**Re: Permit #** SHL18-017  
**Project Name** Lakeshores Group Community Dock  
**Project Address** 5067 84<sup>th</sup> Ave SE (parcel # 407600-0800)  
**Reviewer** Andrew Leon, Planner  
**Department** Planning & Development

Below are our responses to the corrections in your letter dated August 20, 2021. Your original comments are in **bold italics** followed by our response in plain text.

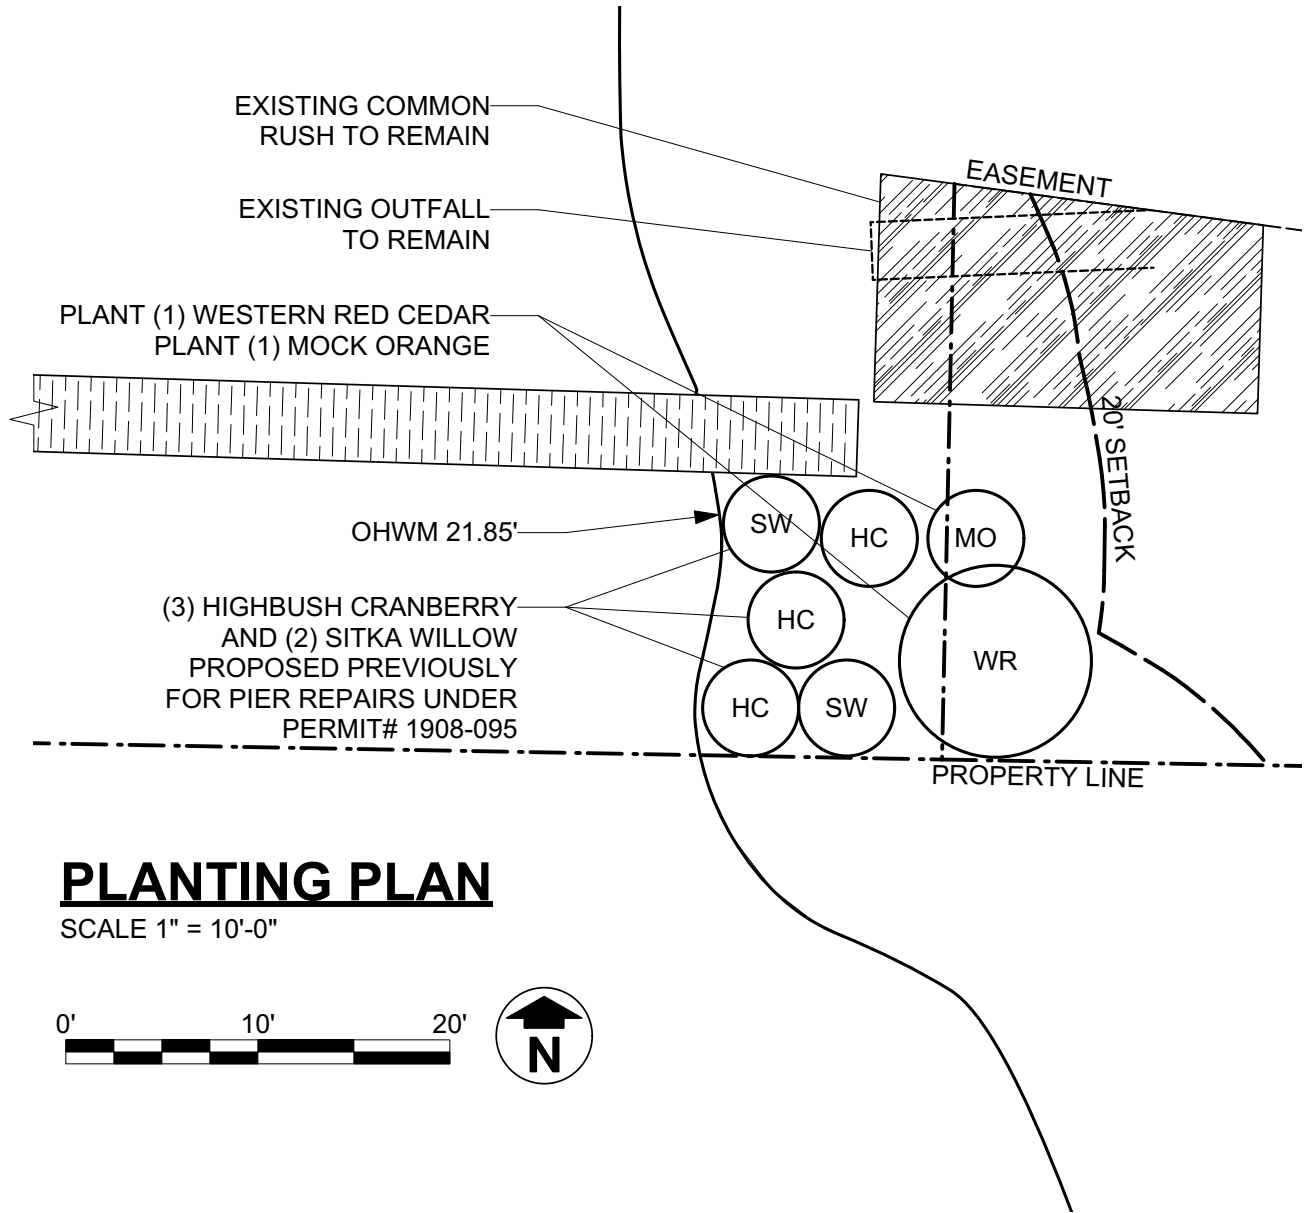
**1. The judgement and decree No. 680150 states in part in Section II "...as owners of Lot 1 through 6 are entitled to build, install and maintain upon the easement area a permanent dock or pier on pilings of a length of 100 feet or a length equal to the docks or piers upon the adjacent properties in the general area surrounding the easement." It appears that surrounding docks have lengths ranging approximately from 60 feet to 155 feet. Please be aware of this easement requirement when considering the dock extension.**

The applicant is aware of this provision and feels that the proposed dock extension complies with this easement requirement.
